**RE: Carlisle and Menaul Development North of I-40, northwest corner of Carlisle and Menaul
Albuquerque, New Mexico**
Submittal Dated May 2, 2025
Via email cvermillion@bhinc.com

Bohannon Huston would like to thank you for reviewing and commenting on the submitted Carlisle and Menaul Traffic Impact Study. Please find the following responses from Bohannon Huston to the review comments dated May 16, 2025.

D PROPOSED CROSS SECTION
NTS

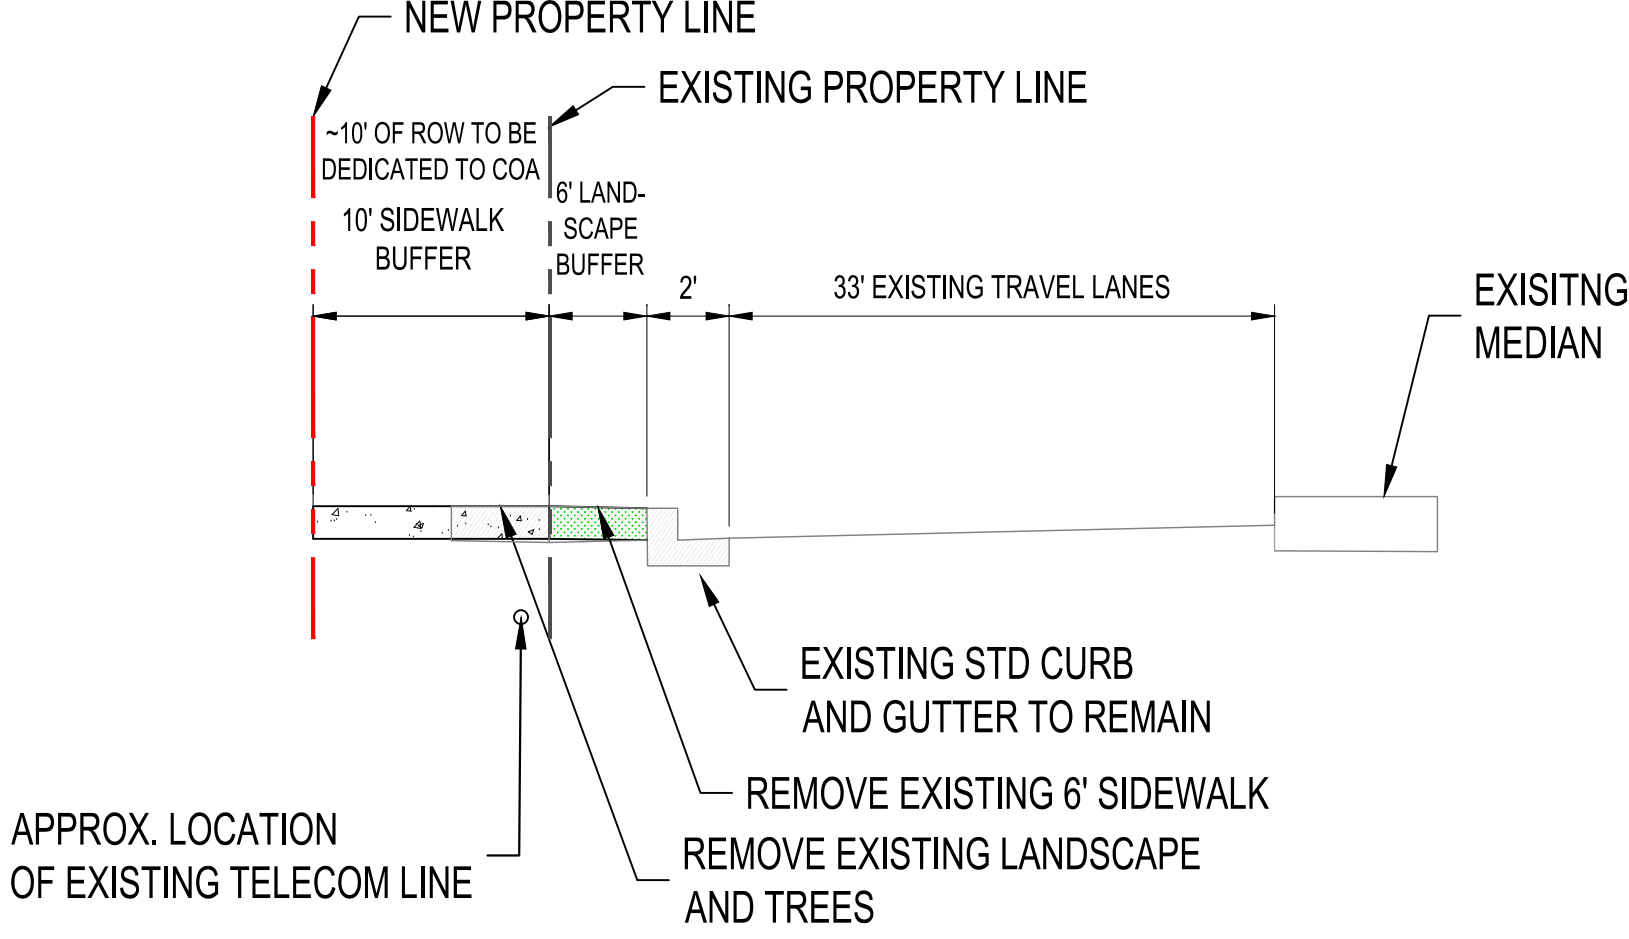
1. The development should reduce the number of conflict points by reducing access points and/or movements. This work should be more than striping to be effective. Or provide engineering studies documenting that more access points for a commercial development is safer than less access points.

2. The development should reduce the widths of its proposed access points to reduce conflict area and provide an engineering design to enhance visibility of vulnerable road users crossing its access points.

3. The development should provide enhanced and upgraded pedestrian facilities along its frontage with Carlisle Blvd and Menaul Blvd. Or verify crash locations by providing detailed crash diagrams based on crash reporting narratives that identify actual locations of crashes and those crash movements at the intersections and segments of roadway within these study intersections to support no enhanced mitigations.

Bohannon Huston Response: In Coordination with the City of Albuquerque, Bohannon Huston has updated the access point at Carlisle and access point 4 to a right-in/right-out only. In existing conditions this access is a full access. This access serves the adjacent business on the east side of Carlisle, so we are proposing to build an island in the access that only allows right-in/right-out movements but still allows access to the east side of Carlisle. See the attached drawing showing this preliminary design.

Bohannon Huston Response: Some existing access points are remaining protected in place with no changes and others will be reduced to minimize the widths. Access 1 on Menaul is currently 20' in width and will remain. Access 2 on Menaul is currently 44' in width. The development is proposing to retain this access point due to larger vehicles accessing the site in the future for deliveries. Access 3 on Carlisle is currently 25' in width. This access is partially on the property of Starbucks and therefore the development cannot adjust this access point. Access 4 on Carlisle is currently 30' and will be designed with a 12' entrance lane, a 12' exit lane with a 12' island that forces a right turn exit. This island will include a 4' sidewalk that extends through it for enhanced pedestrian visibility and decreased distance in conflict areas. Access 5 on Phoenix will be designed to have a width of 26'. The last access that exists on Phoenix will also be reduced to 24' wide.

Bohannan Huston Response: We are proposing to meet the sidewalk and buffer criteria from the City of Albuquerque on Carlisle and on Menaul as shown in the attached. This will include a 6' buffer with a 10' sidewalk along the frontage of the development property on Carlisle and on Menaul.
